**Sunflower Landscapes
Variance of Use
Letter of Intent**

March 31, 2026

PDC File No. VA265

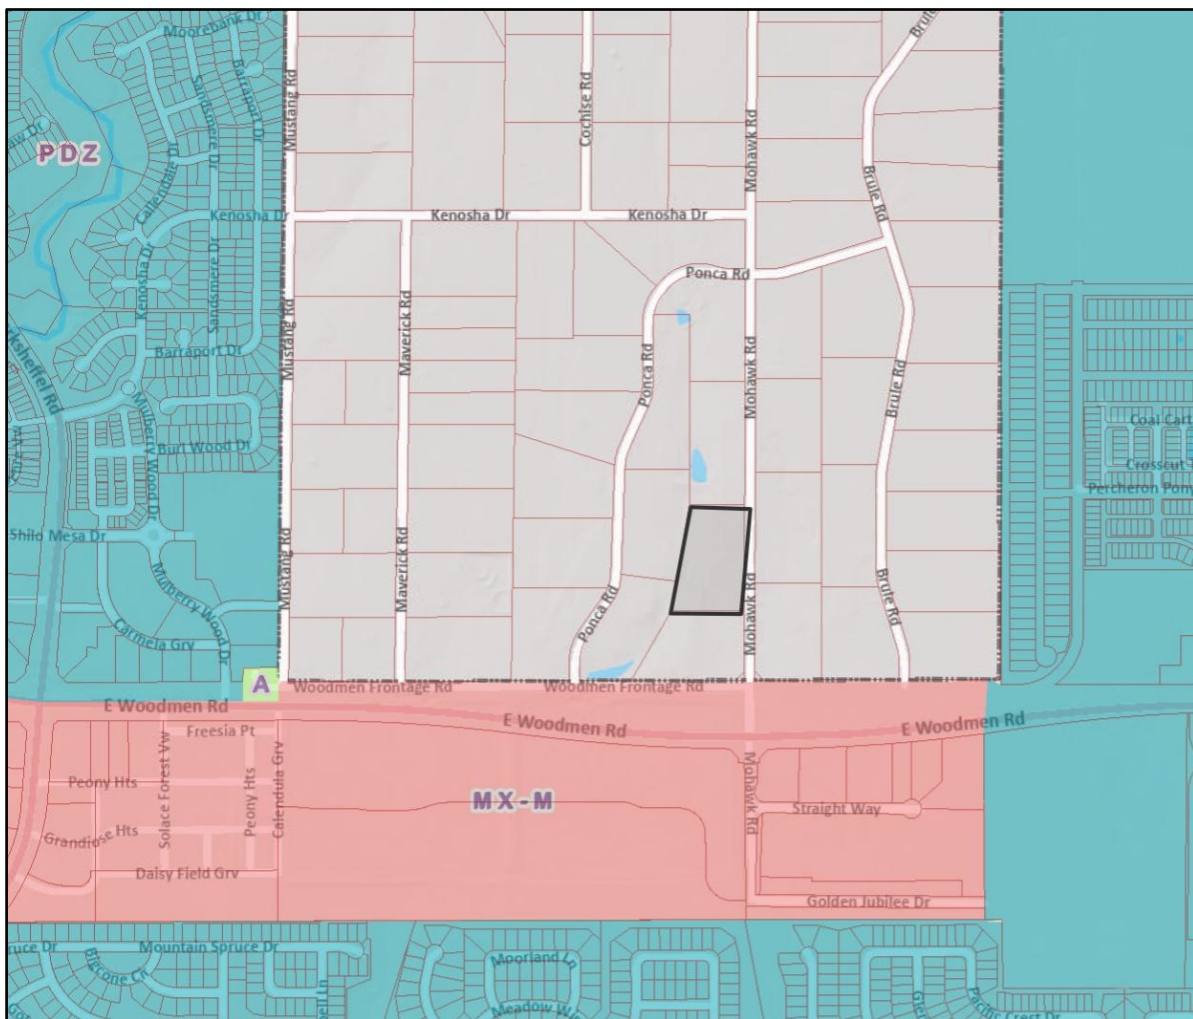
Major unresolved issue: The proposed parking is insufficient and does not demonstrate compliance with the Land Development Code. Although the applicant indicates employees will carpool, this is voluntary and cannot be relied upon to satisfy required parking standards. Please revise the parking layout, number of staff, or otherwise demonstrate compliance with the Code.

RESPONSE: a specific request has been added regarding the number of parking spaces.

The Land Development Code requires a minimum of 1 parking space per area. The site plan depicts a total of 11,721 square feet of building to contractor equipment yard at full buildout. This results in a total of 16 parking spaces required. The owner has planned for a total of 47 parking spaces, which includes parking of equipment and employees. The employees of Sunflower Landscapes carpool to the property, oftentimes in vans. There are currently only 20 employee vehicles onsite at any time on average today. There are more than enough parking spaces planned to ensure there is adequate parking onsite. Please see the Traffic Study submitted in support of the application for additional details regarding trip generation.
